Kirklees Council
Planning and Development Service
PO Box 1720
Huddersfield
HD1 9EL

Date: 03-Feb-2025
Our Ref: 2024/93485

**Discharge of details reserved by conditions 4 (Phase I Desk Study Report) , 5 and 6
(Phase II Intrusive Site Investigation Report),
9 (Charging Facilities) 10 (Public Sewerage Infrastructure) on permission
2023/93273 for erection of two storey rear extension and extension to car park
Shaw Cross House, Shaw Cross Business Park, Shaw Cross, Dewsbury, WF12 7RF
Application Number: 2024/93485**

Title: Proposed Site Plan

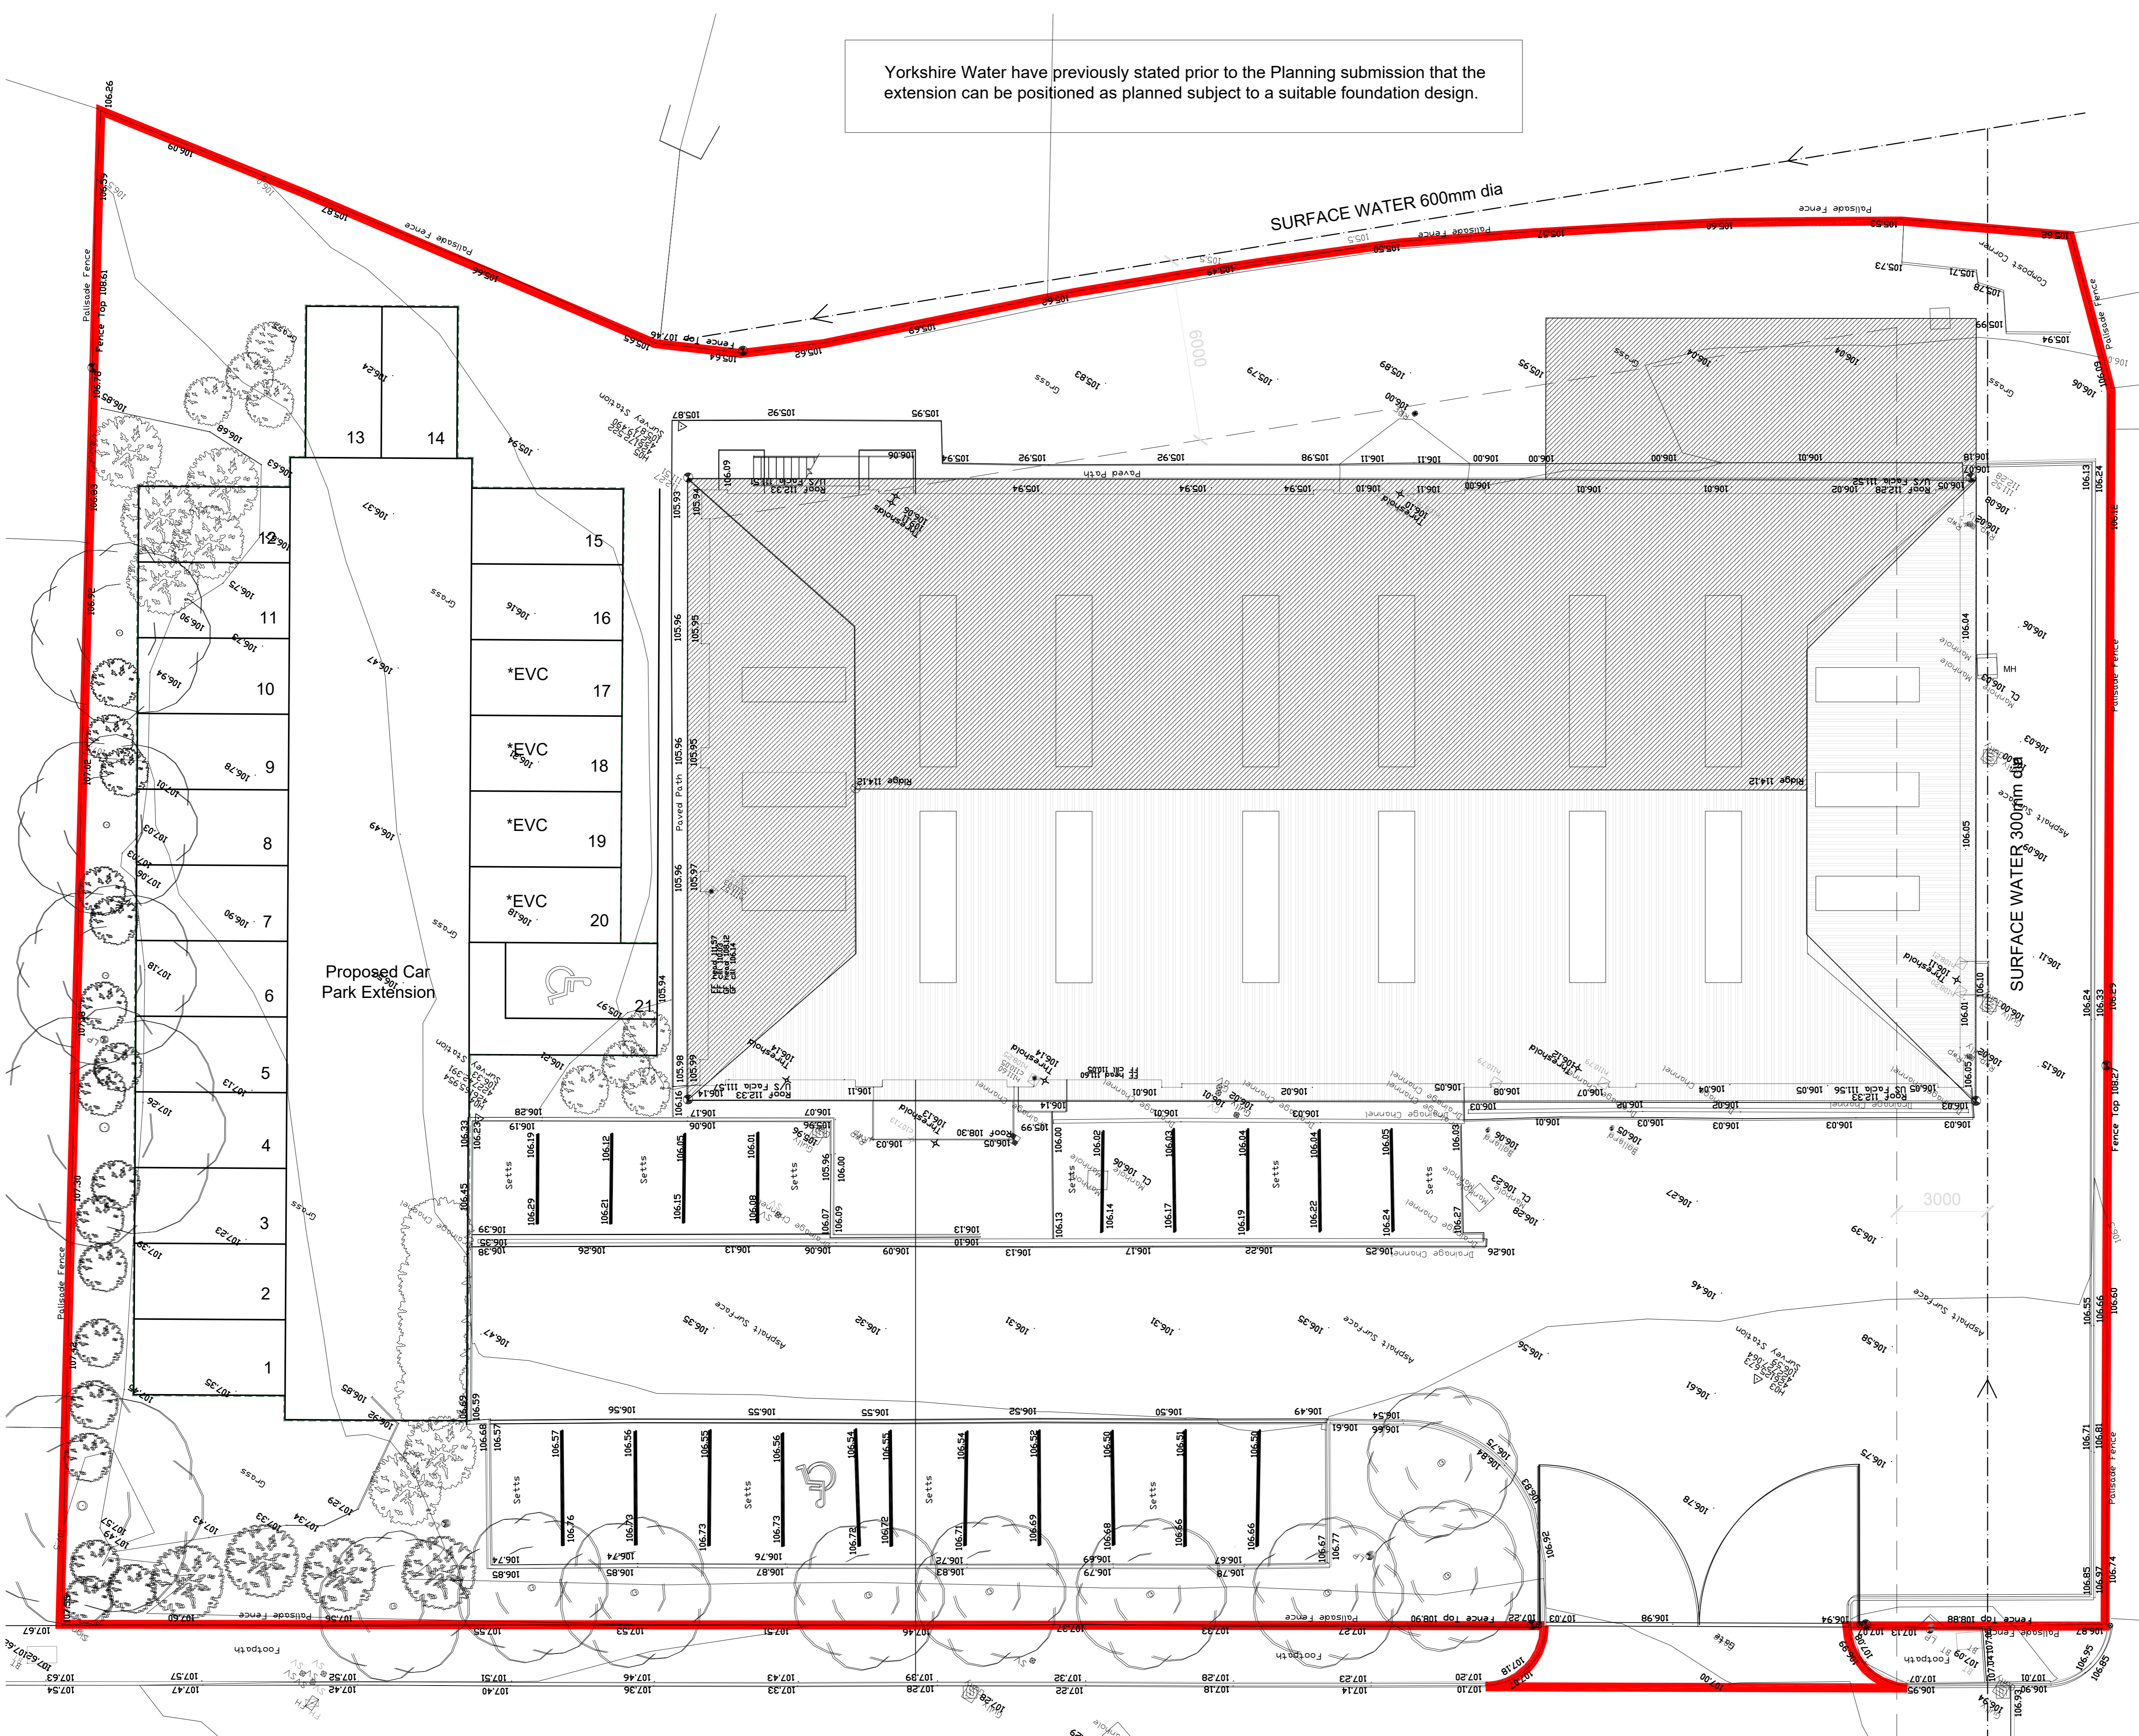
No technical specifications have been provided to confirm that the charging points meet the minimum requirements as specified in the West Yorkshire Low Emission Strategy (WYLES) guidance. Therefore, further information is required before KC Environmental Health can consider the application further.

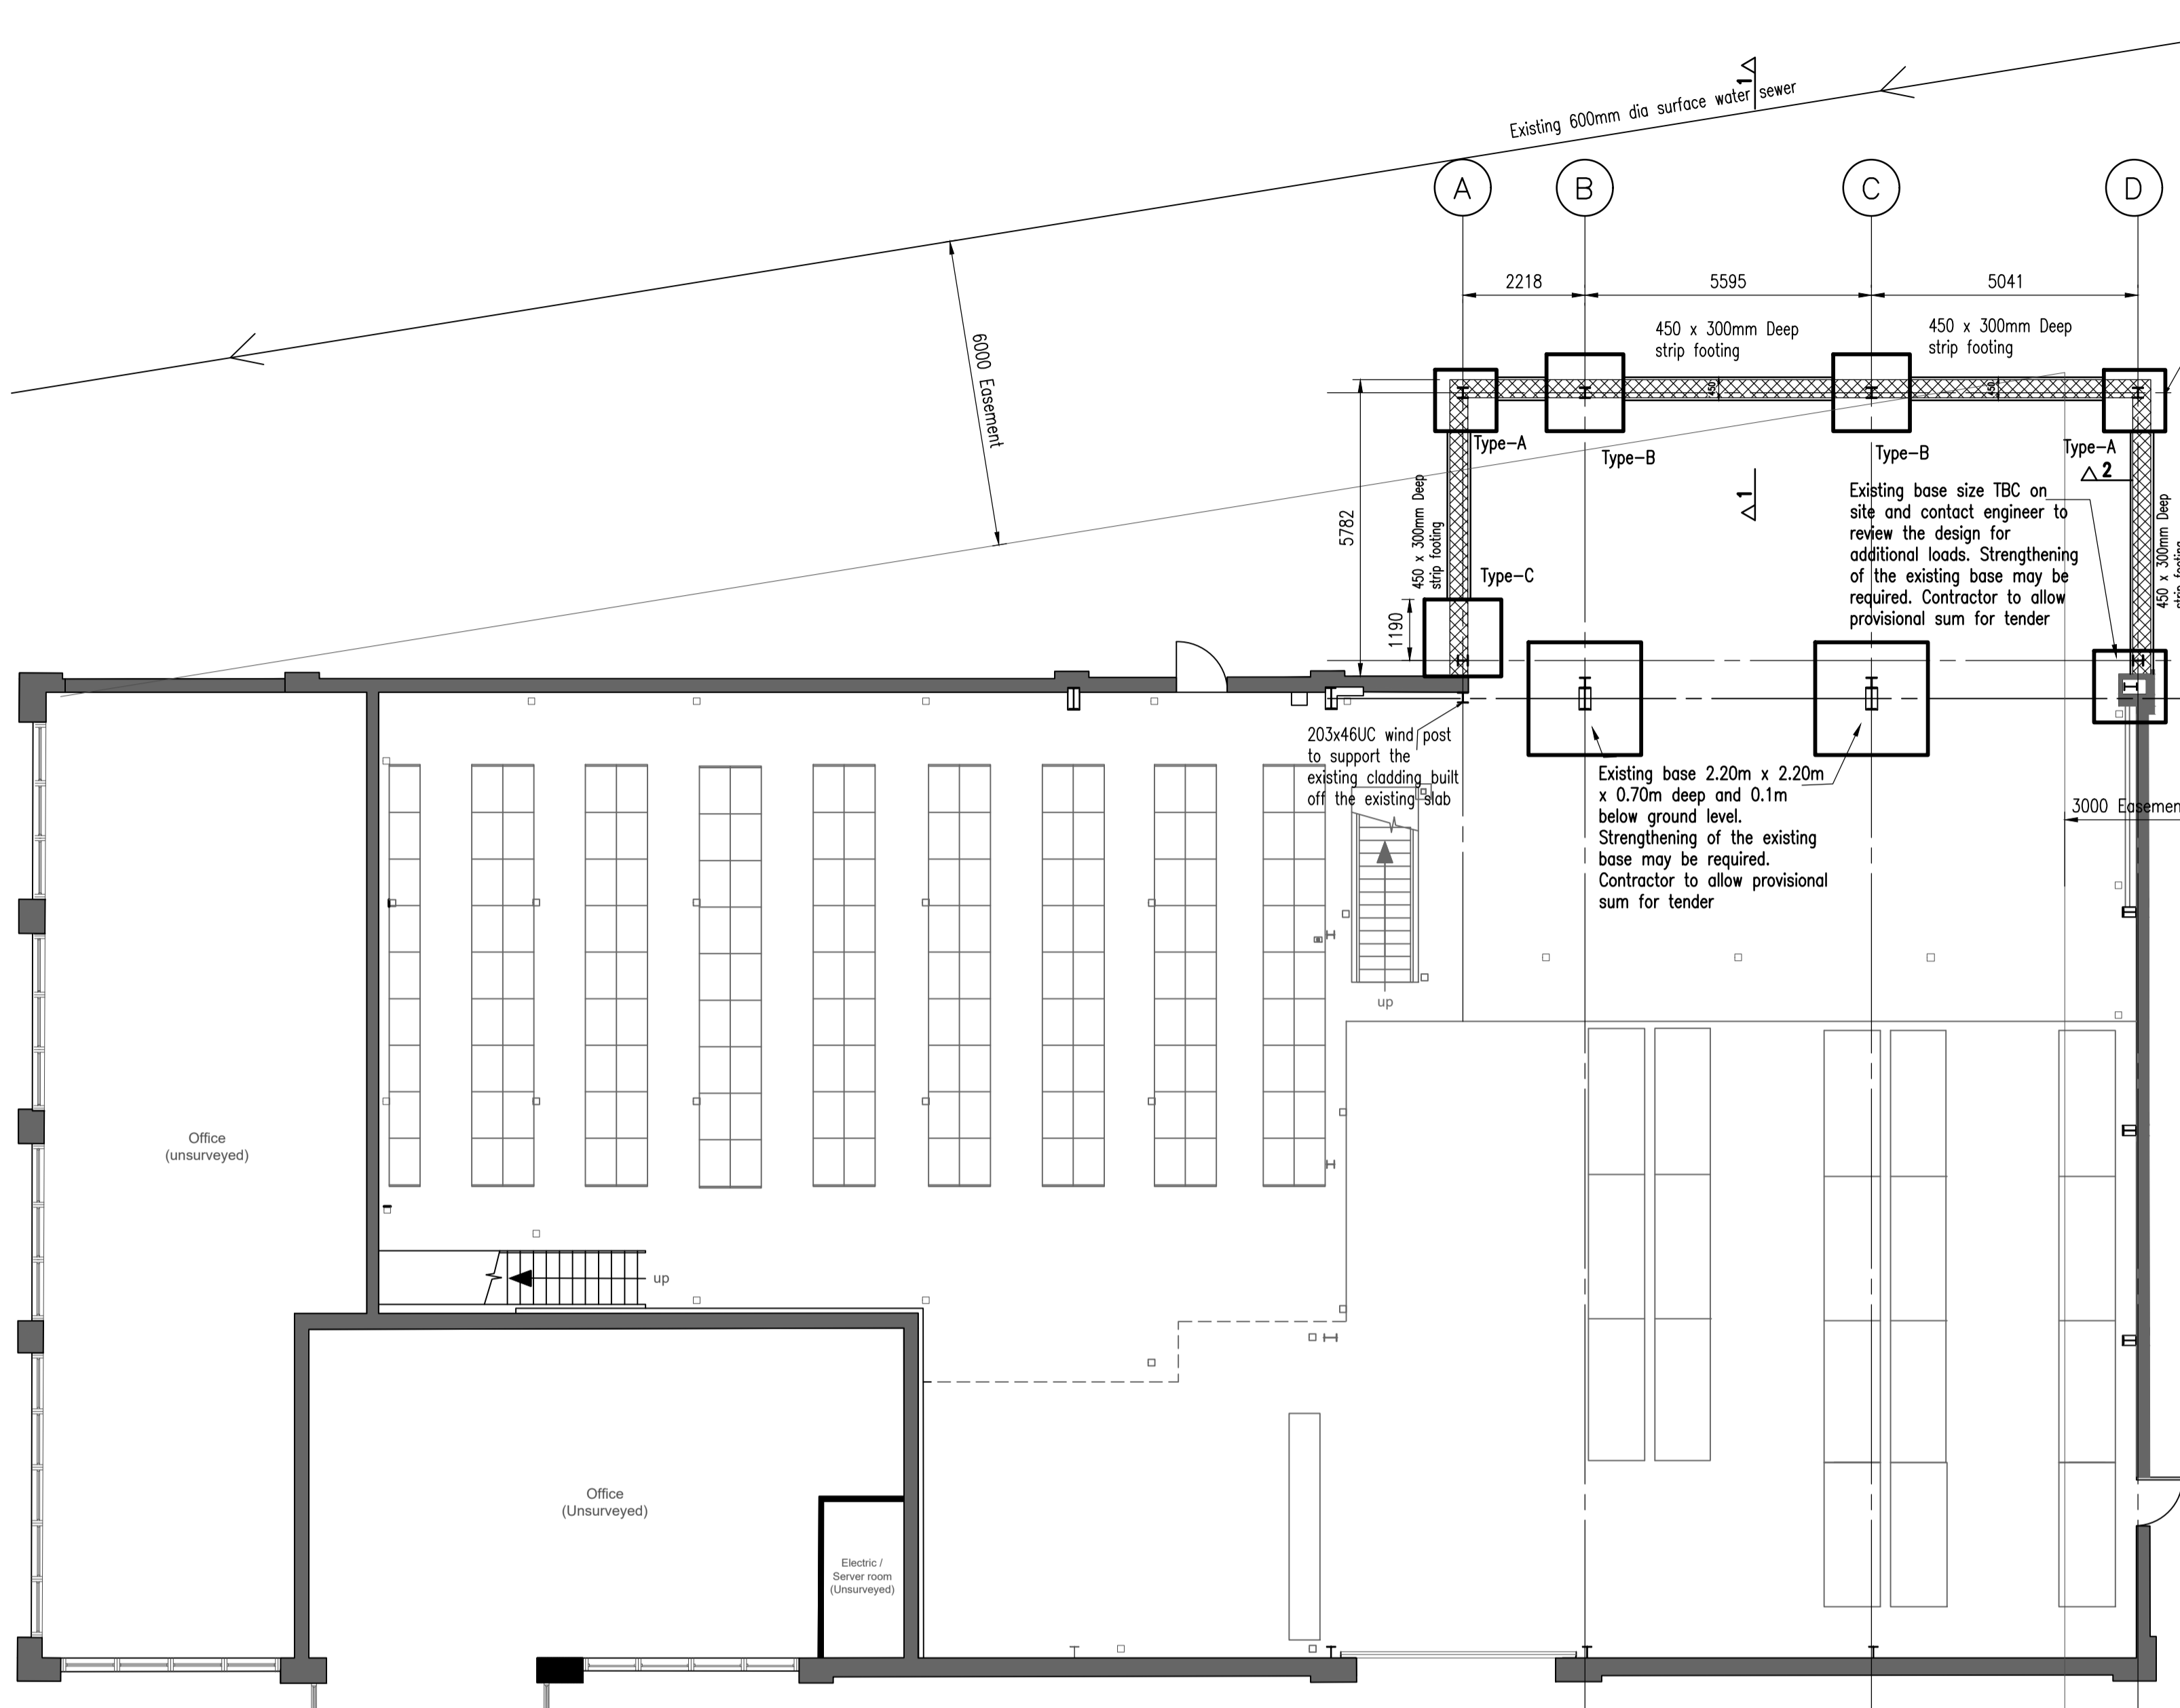
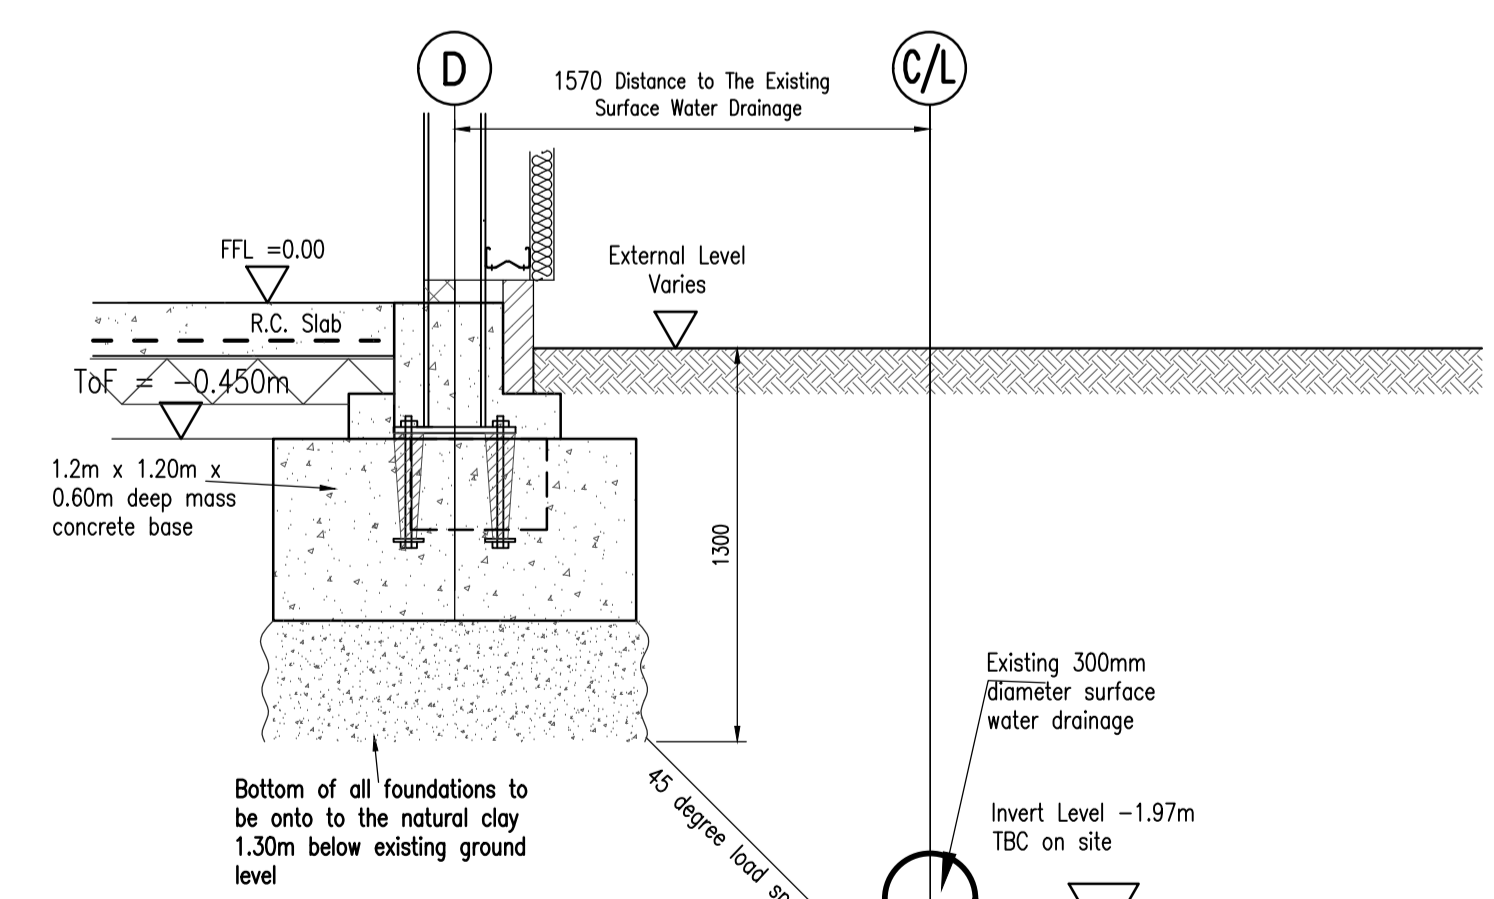
In conclusion, it is considered that further clarification is required for the purposes of discharging condition 10. Therefore, Condition 10 should remain until further notice.
